SSD-9472 Sikh Grammar School
Lots 42 & 43 DP30186 151-161 Tallawong Road Rouse Hill

The following forms our submission regarding the above Development Application for a proposed school. We are making a submission on behalf of 129 Cudgegong Road Rouse Hill (129 Cudgegong Road Pty Ltd).

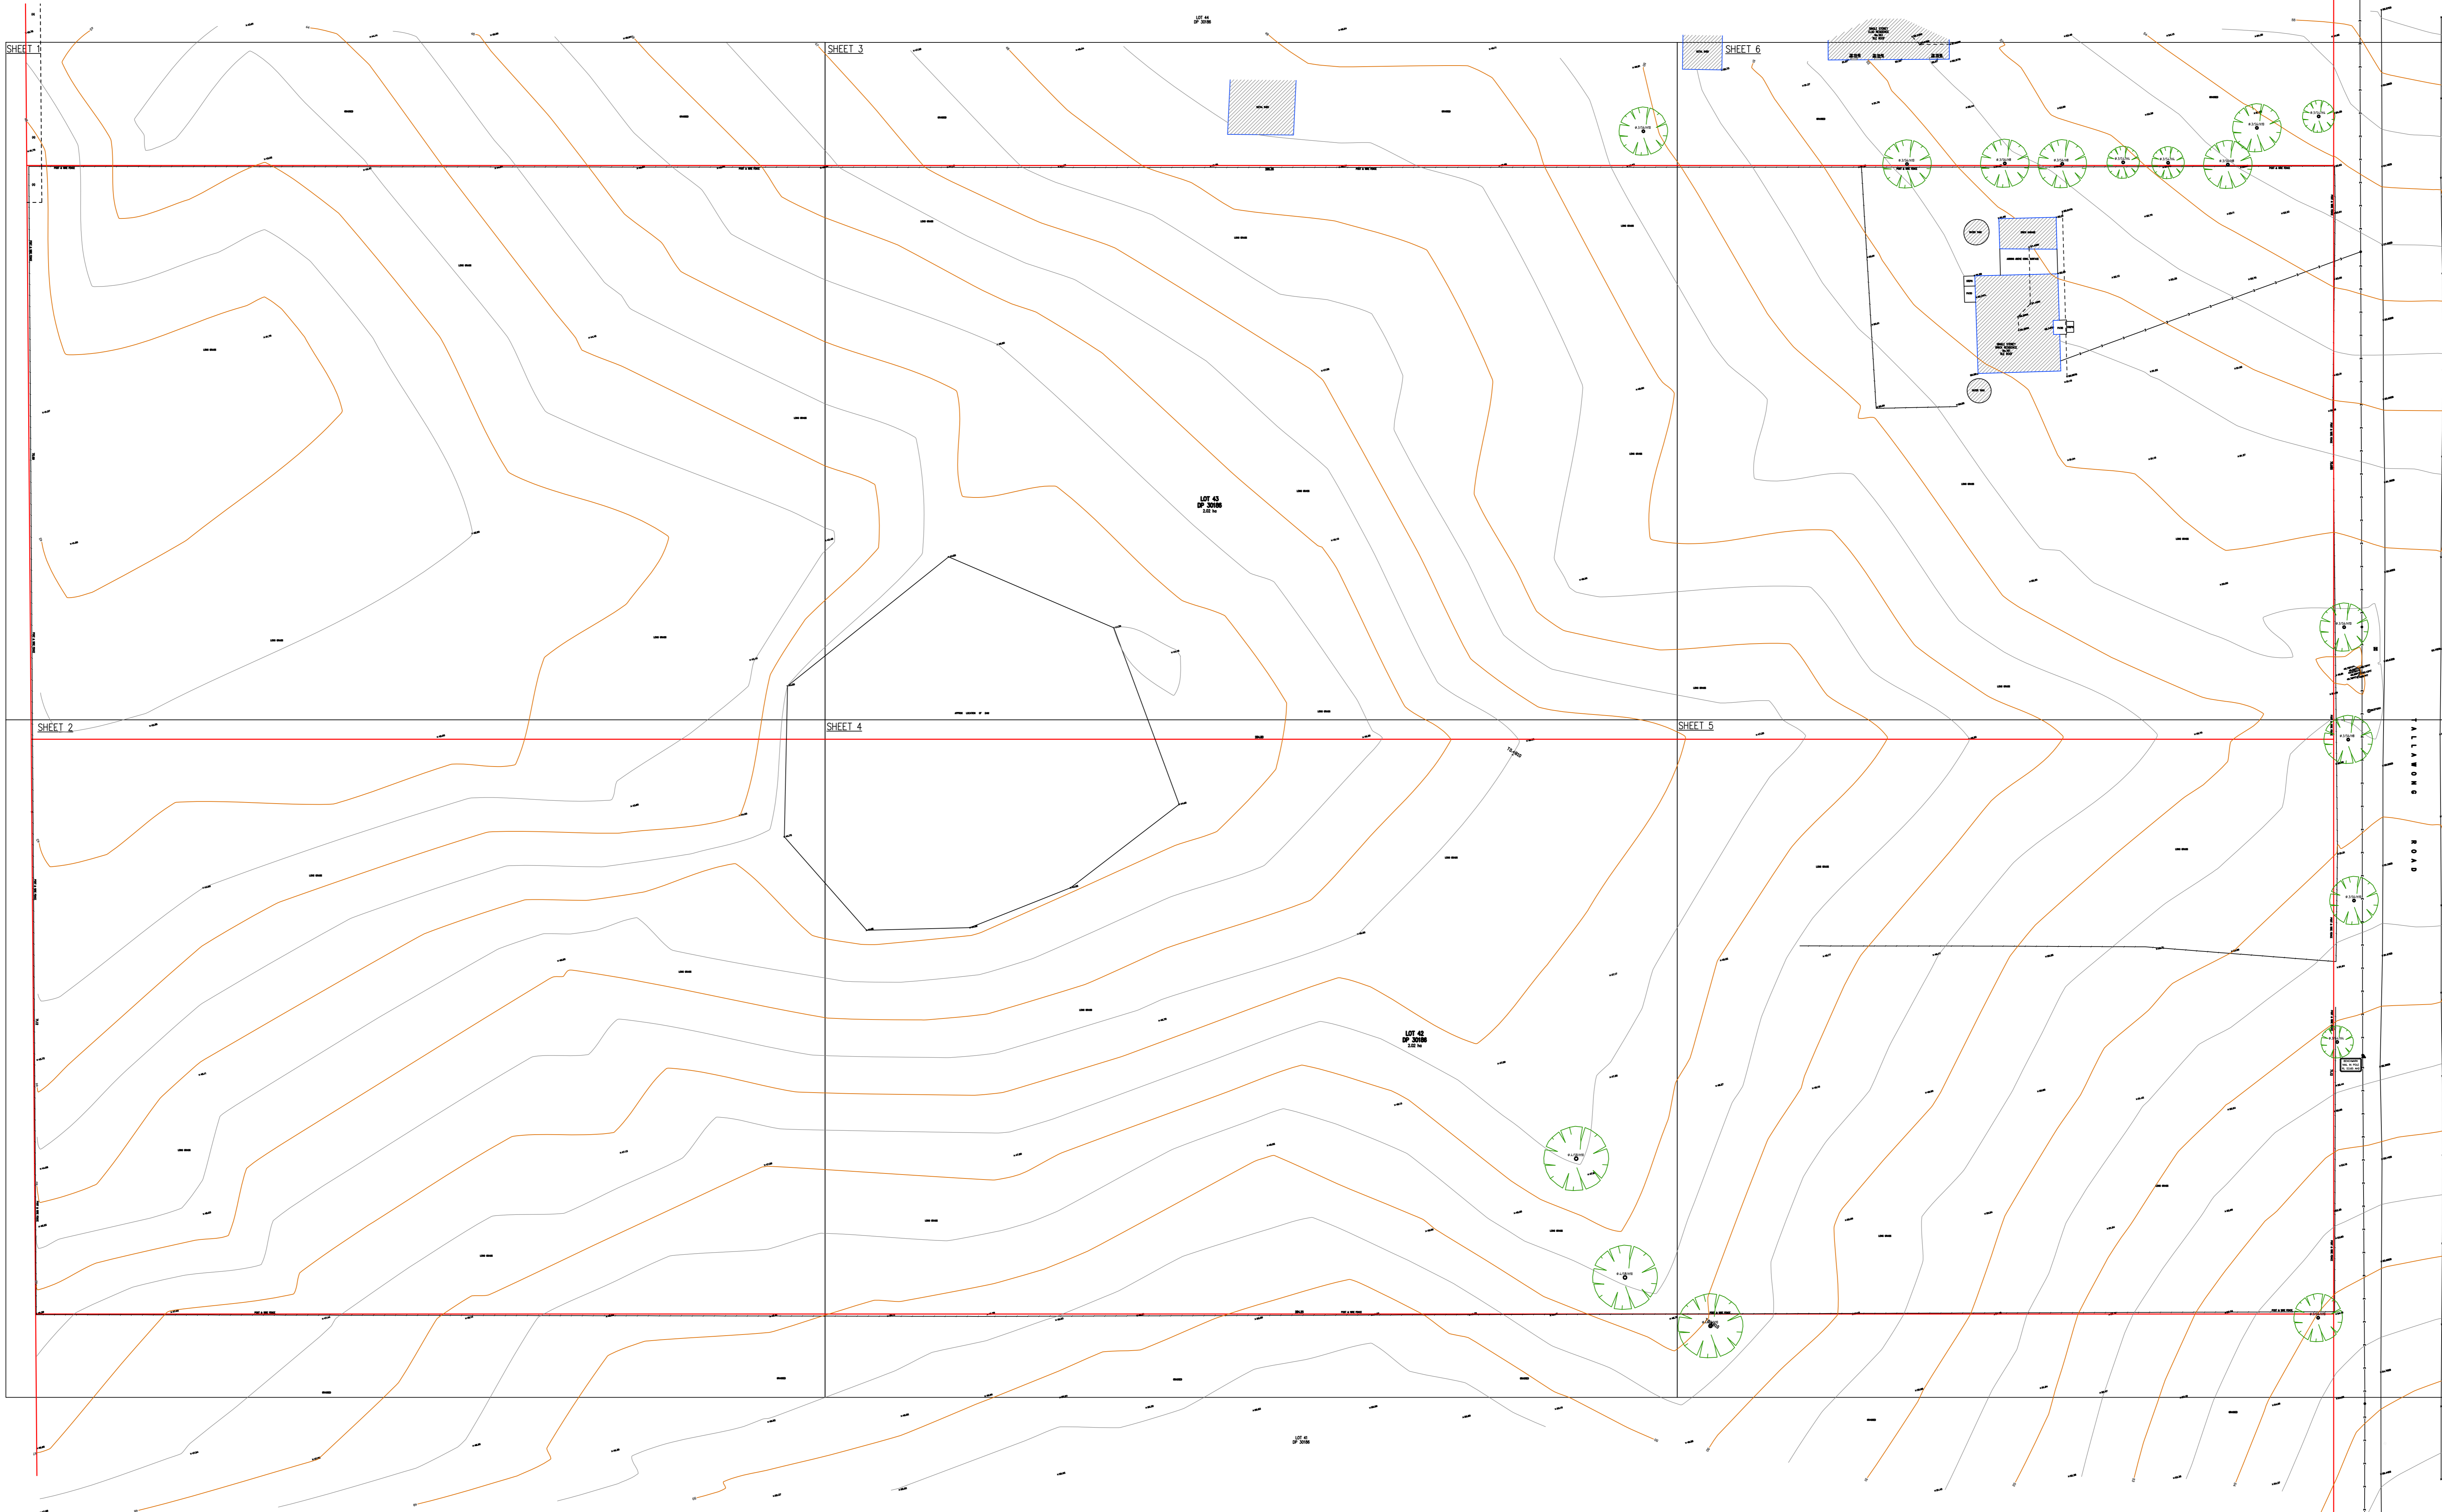
- The survey plan is illegible as only Sheet 1 has been included whereas Sheets 2-7 which have not been included presumably provide a greater scale and legible text.
- The architectural plans do not provide any measurements from natural ground level making precise measurement of the building height and impact on the adjoining properties difficult.
- There are significant inconsistencies between the masterplan and the architectural plans. Building locations are substantially changed, land uses have been relocated and parking areas, bus layby and access arrangements are different.

01 PLAN
Site-Overall
Scale: 1:200

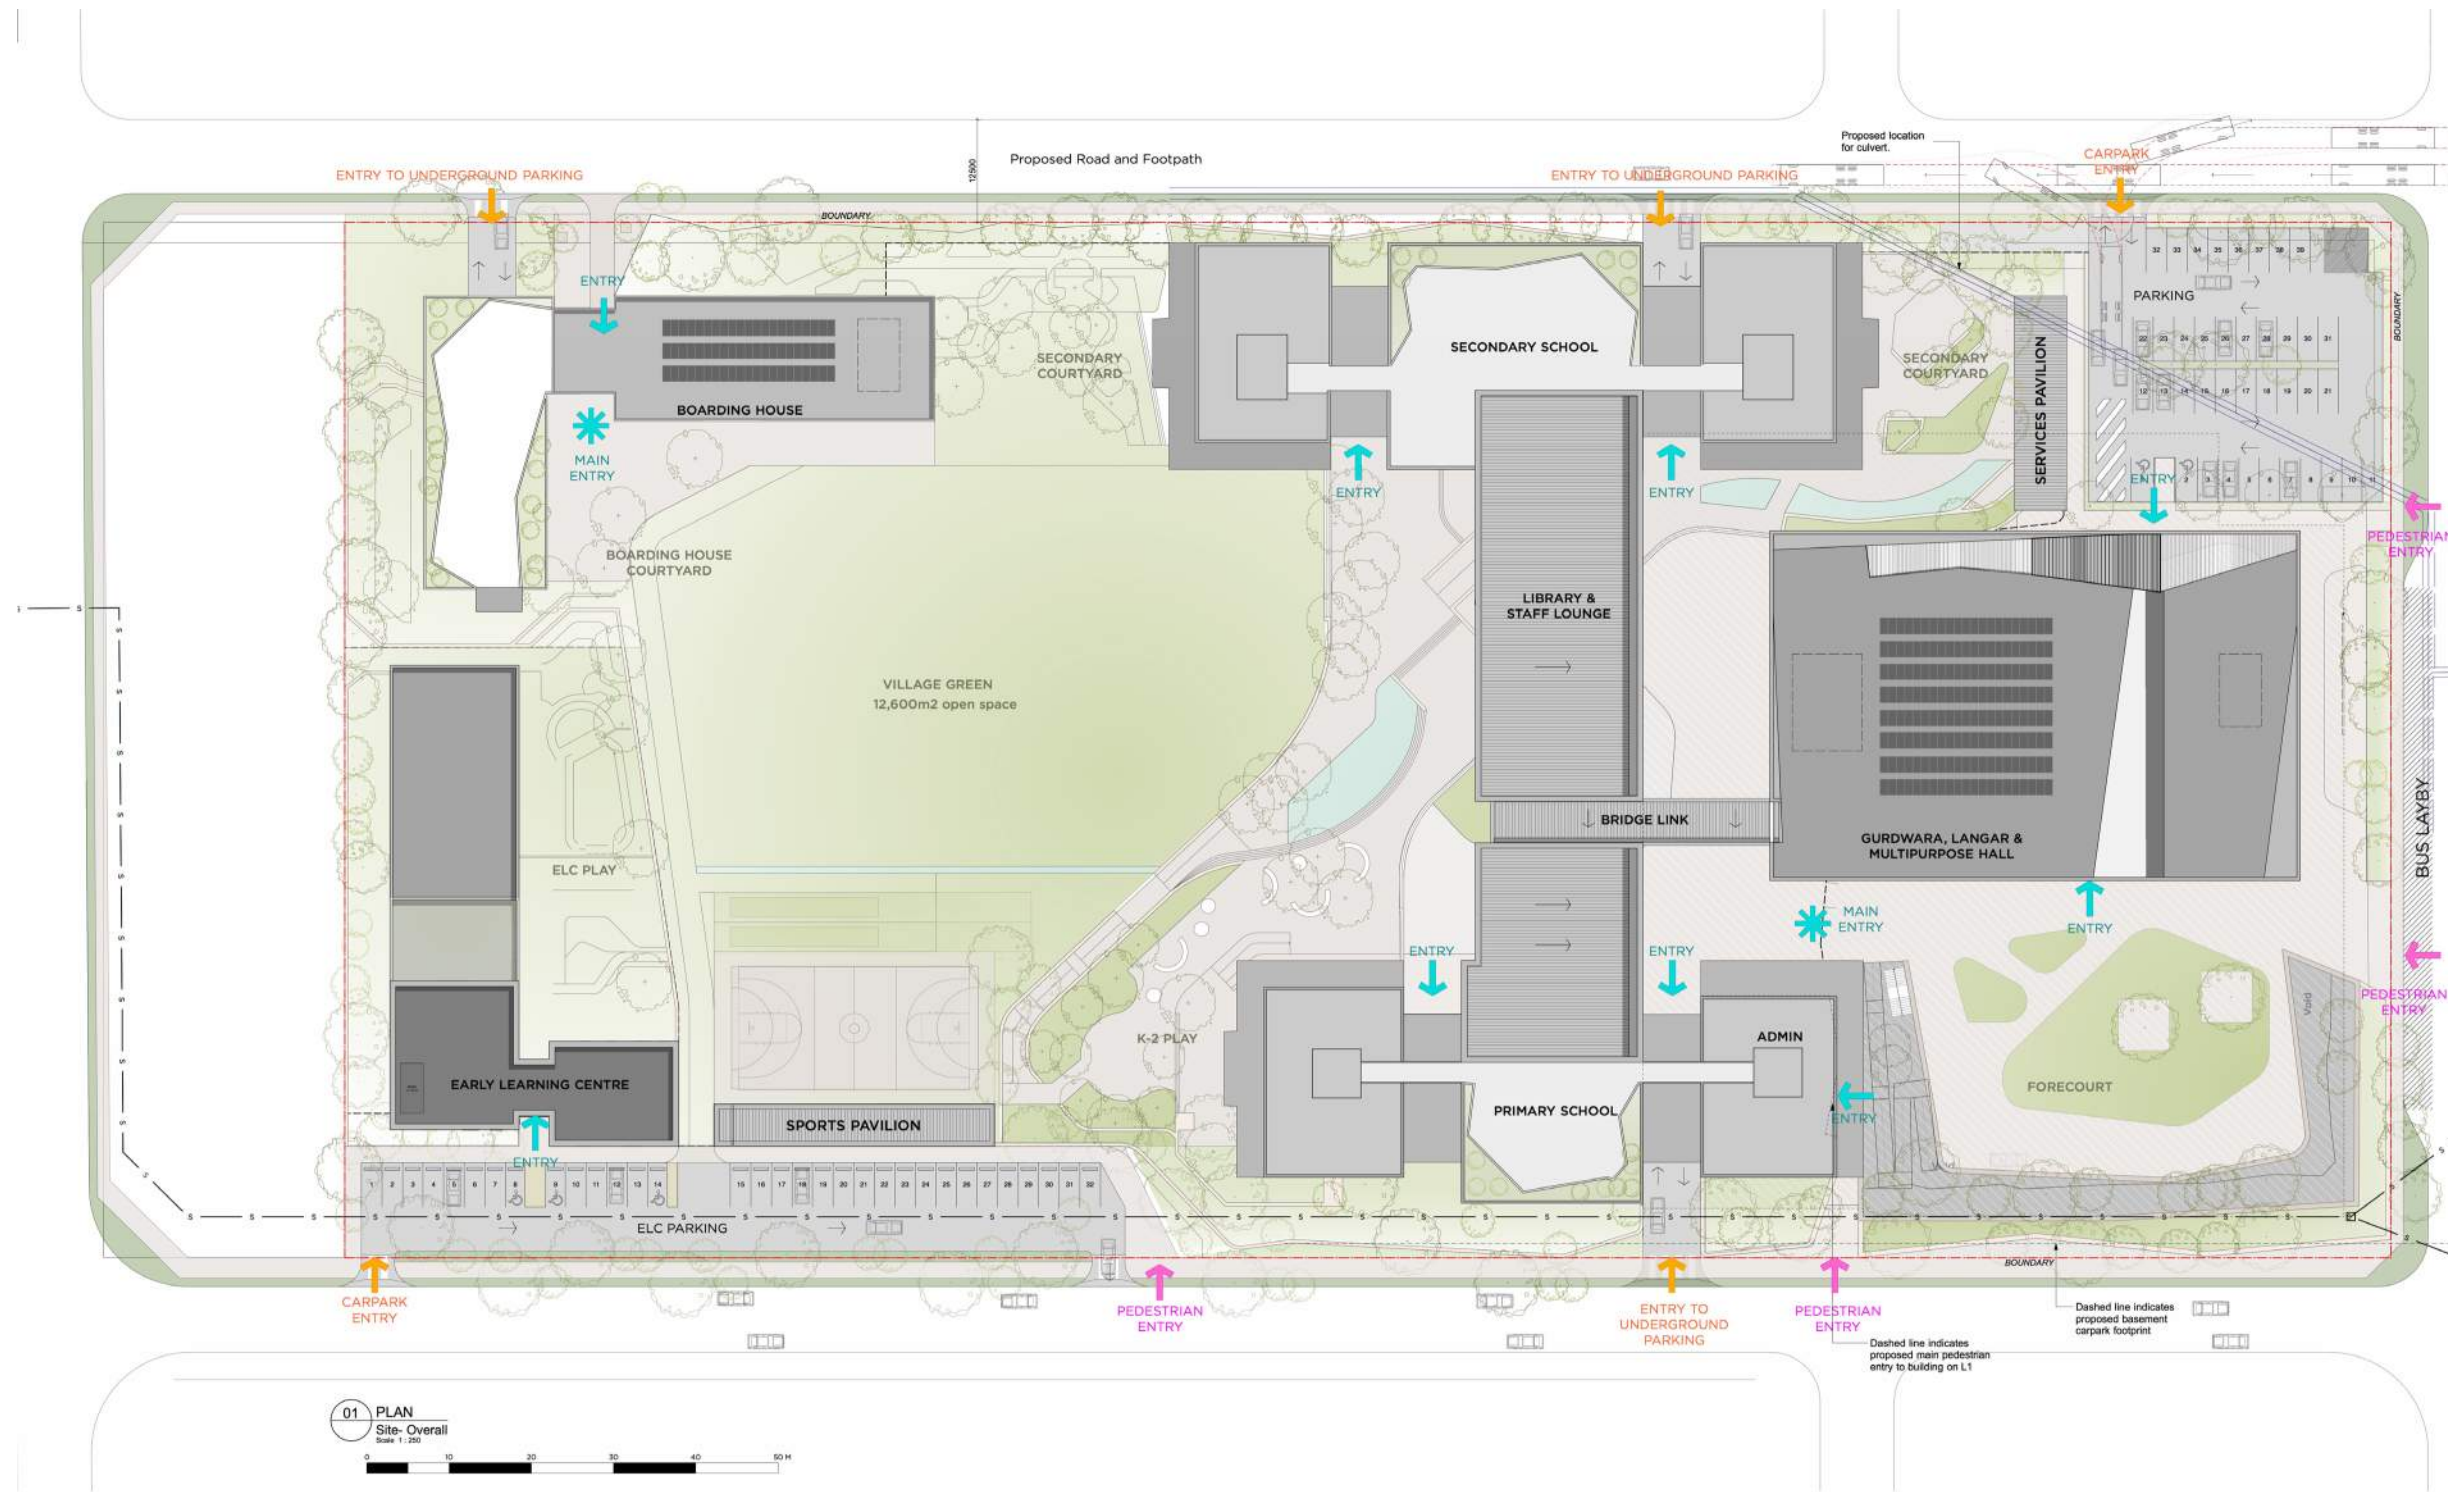
Additionally, the turning manoeuvres indicated on the architectural plans cannot be accommodated without driving into our property, and no consent has been given to temporary or permanent works within our site.
